From: Amanda Scholes on behalf of Planning.Responses
Sent: 26 July 2017 10:28
To: Planning Scanning
Subject: FW: Fitzalan Link - LU.234.16.RES

Following review of the submission, WSCC comments as follows:

In summary, there appear to be just three outstanding points now – the choice of road surface, the requirement for a new or supplementary Stage 1 Road Safety Audit and the design of the shared footpath-cycleway connection to Highdown Drive close to the new

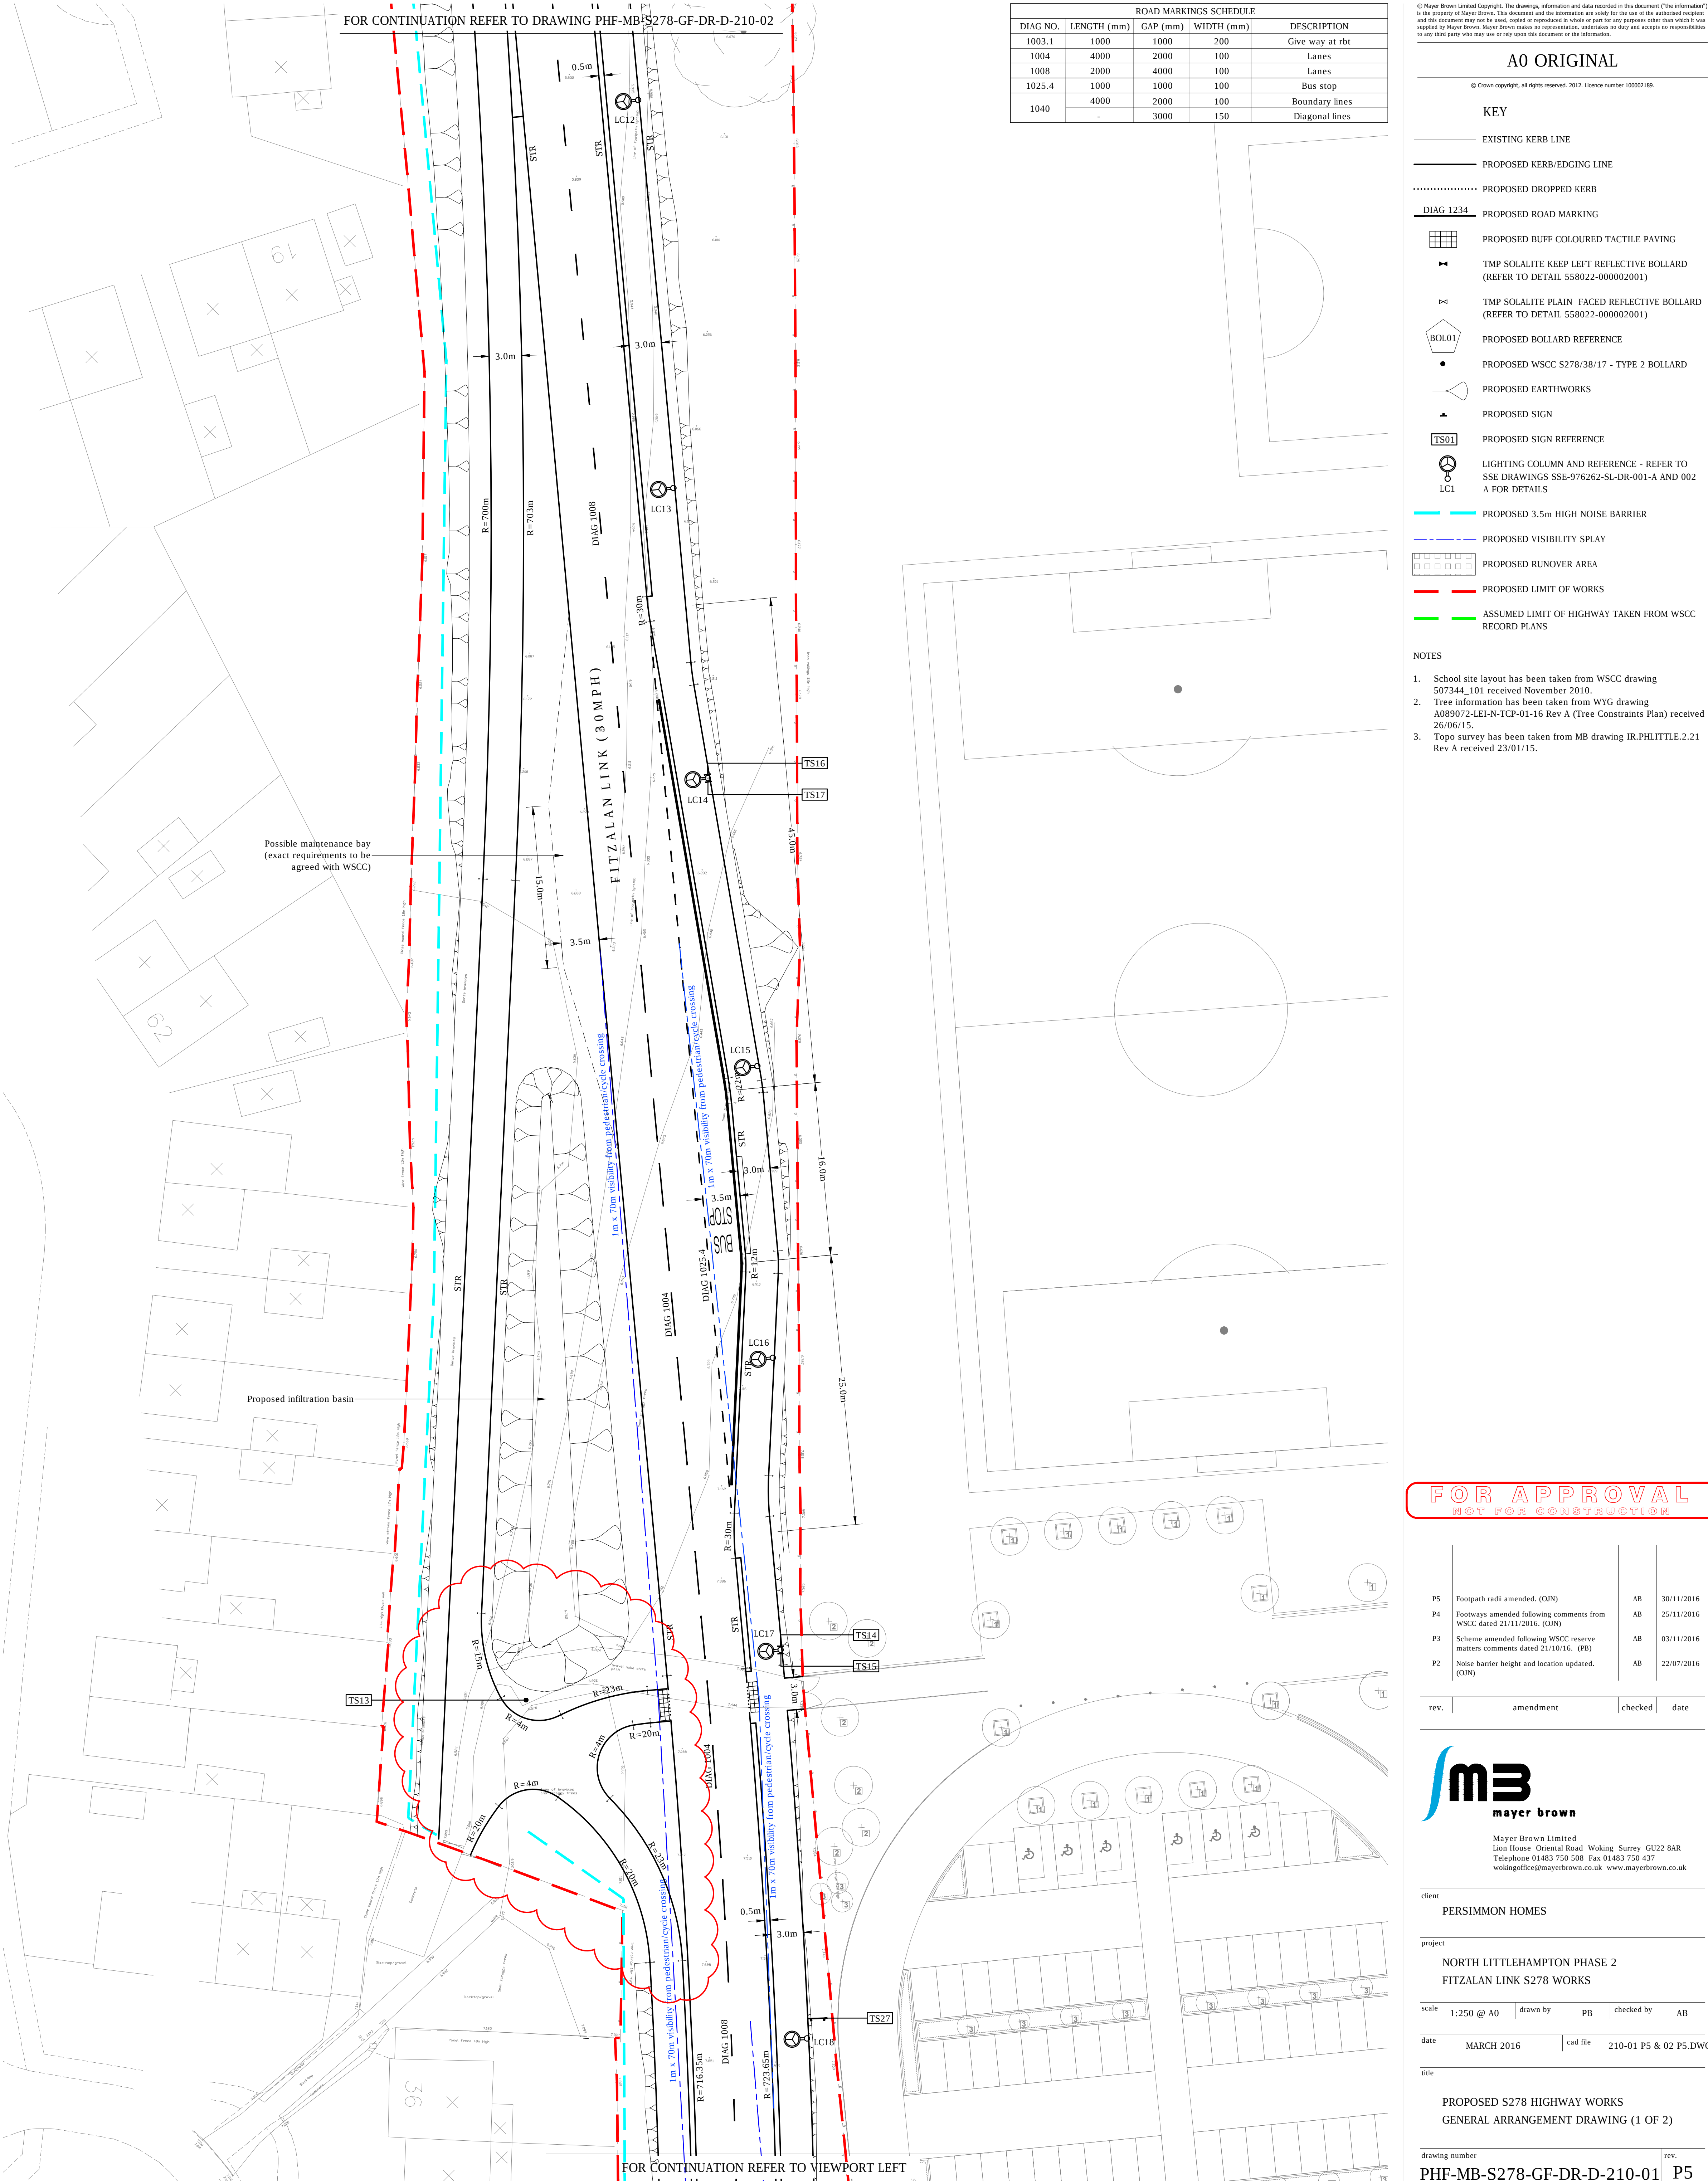
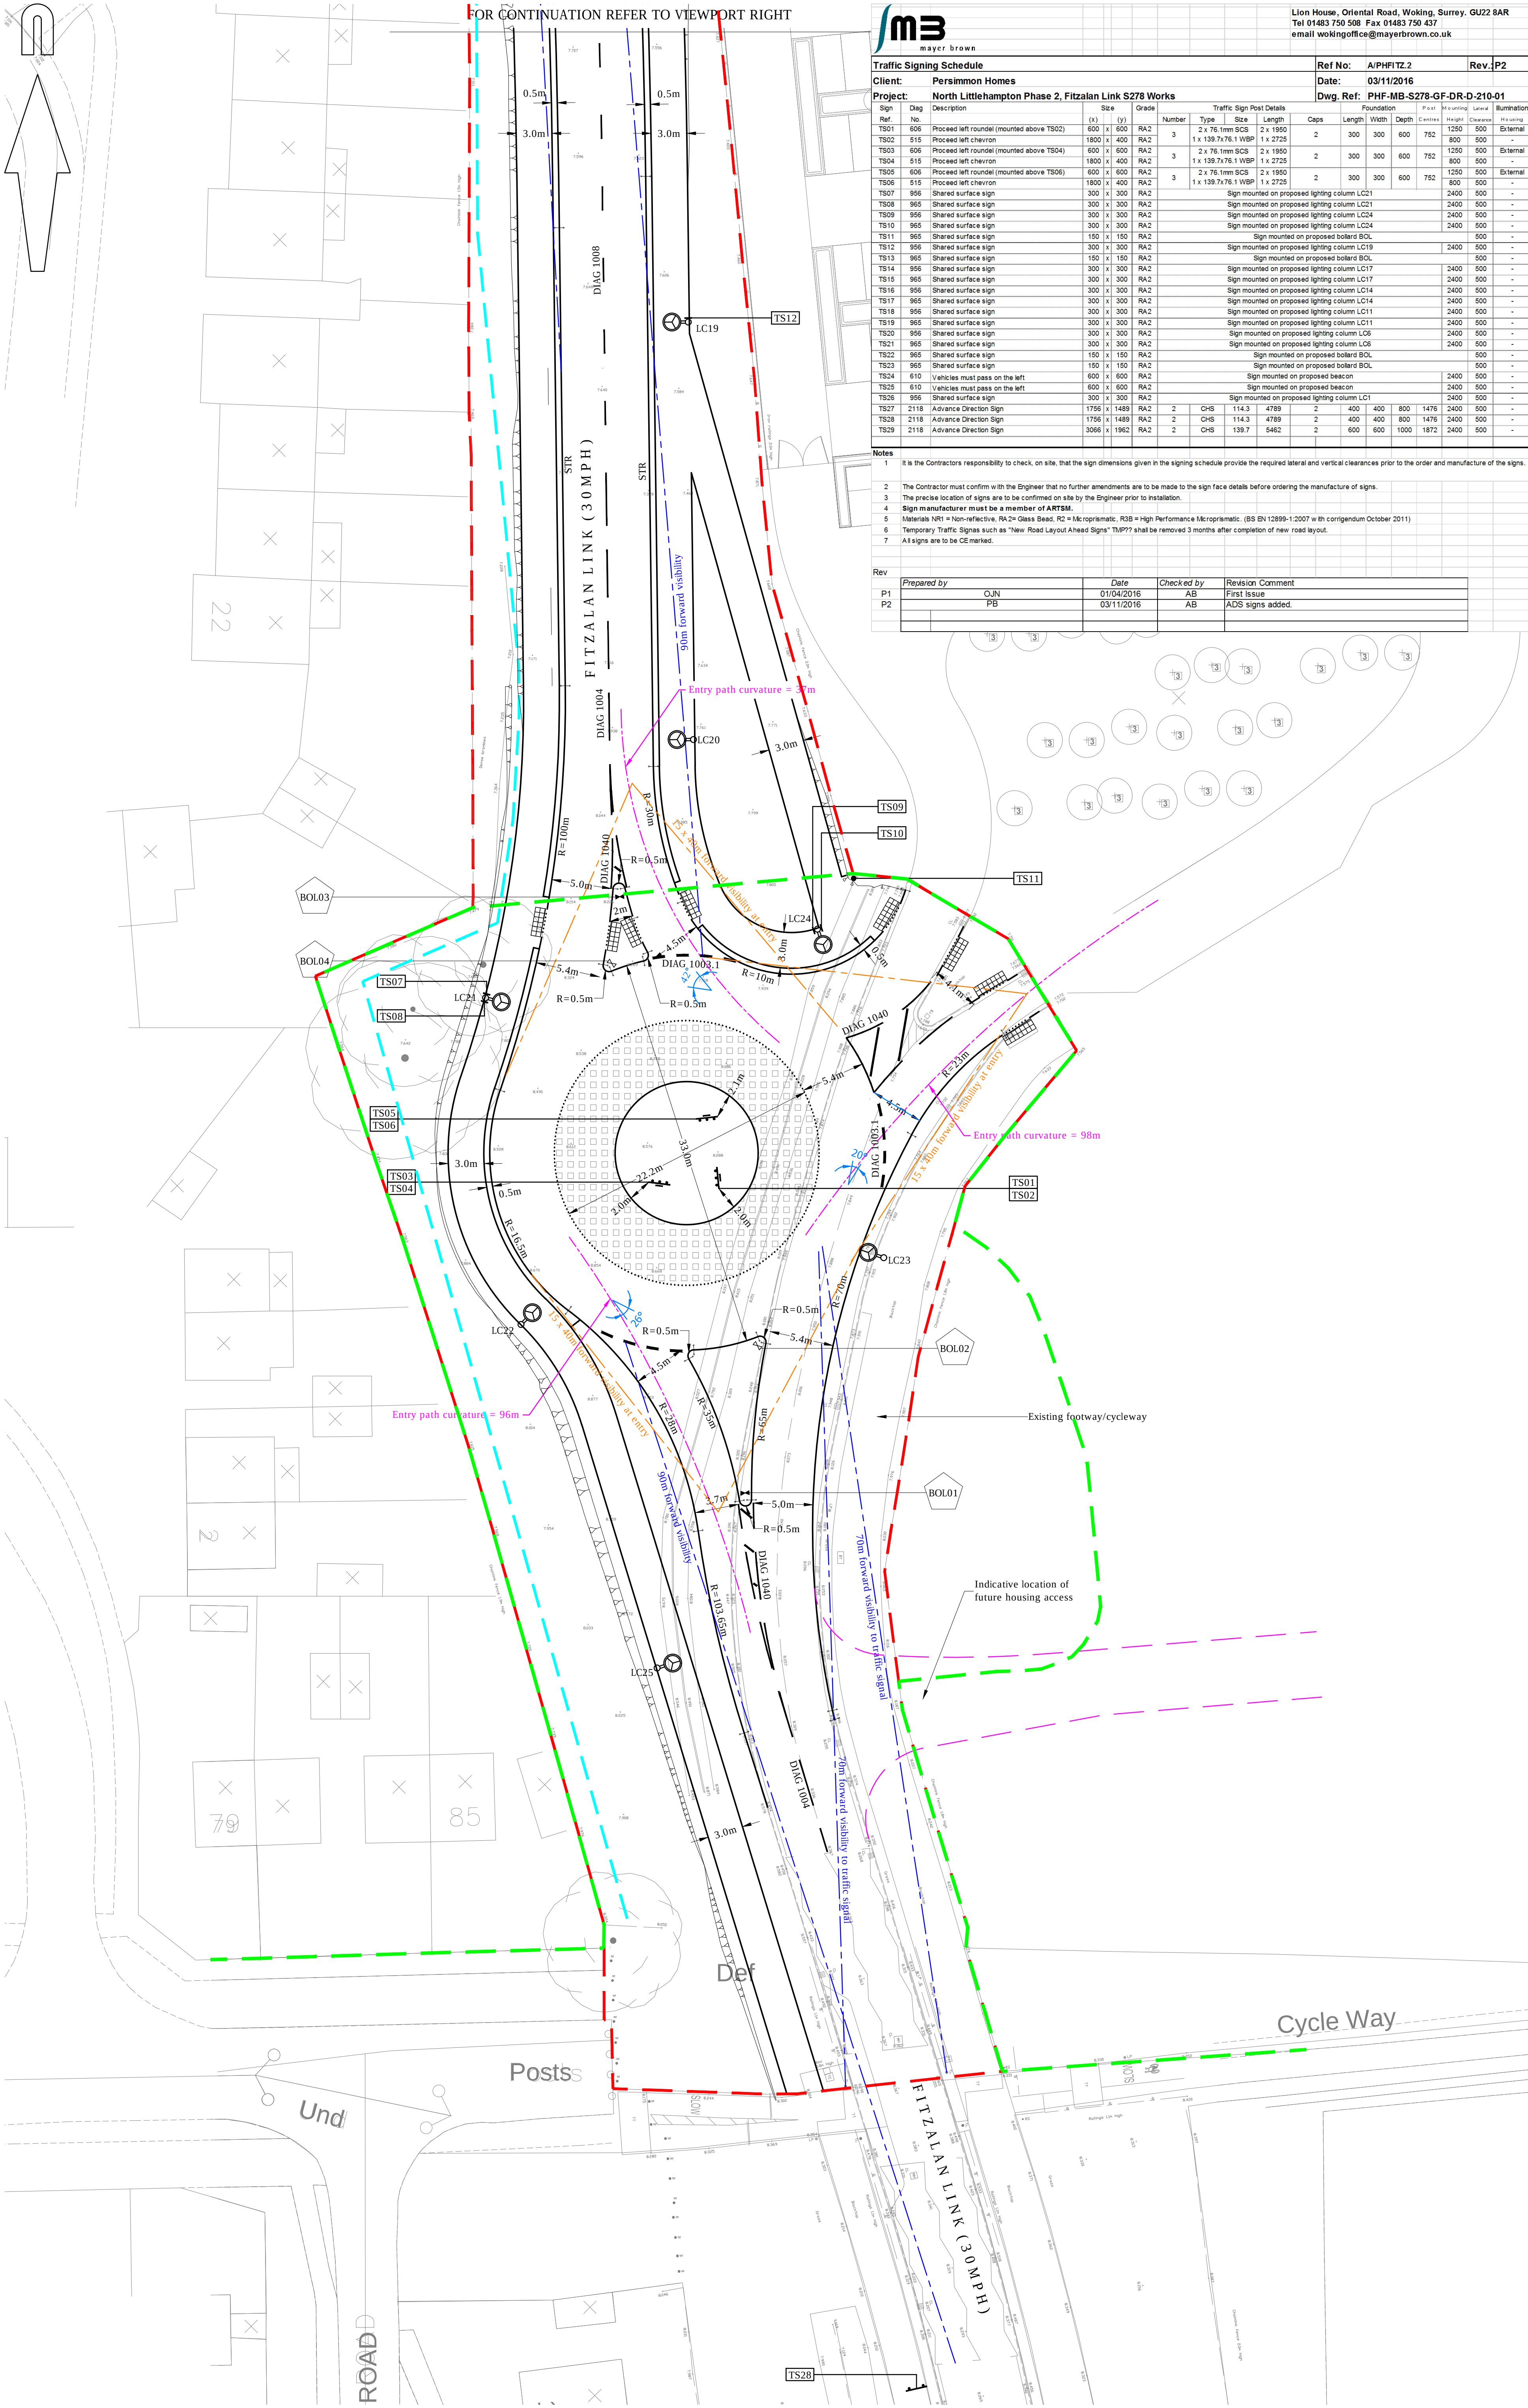
The drawings show a pervious road surface. This will not be long lasting enough. The best WSCC can consider is a negative textured road surface. However, this will not absorb as much noise. Your designer will need to look into "German SMA" which is an SMA with a high binder content and use an appropriate noise reduction factor.

Pedestrian crossing point at college Roundabout Northern Splitter island.

Academy roundabout northern traffic island has a tactile paved crossing point. Given that it is narrow (the tactile paving on the drawing appears to 'meet'), consideration should be given at the S38/S278 stage to widening it or adjusting the position of the tactile paving (if possible) to improve width for pedestrians. However, in doing this you should also ensure that the swept-path of vehicles can still adequately negotiate the roundabout without compromising safety for pedestrians on the island.

Toucan Crossing.

Recommend that at the detailed design stage, the cycleway on the east side be locally flared at the controlled crossing to provide additional width for waiting pedestrians and cyclists. Also, that LC 17 be moved to the very back of the space available, away from the area of conflict where there would be interaction between pedestrians and cyclists. WSCC recommended to increase the crossing width beyond the minimum so as to provide more space for waiting pedestrians in order to help keep the cycle route clear. The location of the control box must be carefully considered to avoid obstruction for users and visibility. Finally, it is recommended that corner radii be applied between the cycle paths at the school exit next to the crossing and that pedestrian and cycle intervisibility is provided at this location.

Bus stops and laybys.

Thank you for showing a northbound bus stop and layby. Where possible (and again at the detailed design S38/S278 stage), additional path width should be provided at *both* bus stops to allow passengers to wait clear of the cycle path. Also, please consider where bus shelters might be placed, and what form these would take given the space available.

We sought to reduce carriageway of the road to 6.75m as this would have the effect of constraining speed closer to the proposed 40mph speed limit requested by WSCC. As a result, HRA (standard surface) could be provided. Our noise consultants have assessed the impact on noise relating to a speed limit of 40mph and with a HRA surface course finish (standard / noisiest surface) and this includes that speeds of 42mph would be okay in terms of the noise assessment submitted and enable a 3.5m noise barrier to provide sufficient noise mitigation. WSCC's 2010 speed policy refers to an average speed of 42mph for a 40mph road. Thus the above would appear appropriate

Noted. We shall review to see what changes can be made to accommodate a larger island as requested.

Noted. We shall review to see what changes can be made.

We have been clear that space is restricted to provide this late edition facility (which we are doing to accommodate an WSCC oversight on the section of the Link Road they have already delivered). We 'may' be able to provide an increased width footway of 3.5m on the western side, but we will need to review the levels so this can not be guaranteed and should not be used as a means to hold up this application. Otherwise, if the footpath width is crucial then we will not be able to provide a bus stop at all. In terms of bus shelters we can provide one but is likely to restrict foot / cycle path width even more. Furthermore, this seems a bit onerous given that the outline doesn't actually require us to provide a bus stop. We consider that an open bus stop is appropriate, especially given the width restriction and if a shelter becomes necessary at a later stage WSCC could fund this with wider infrastructure contributions.
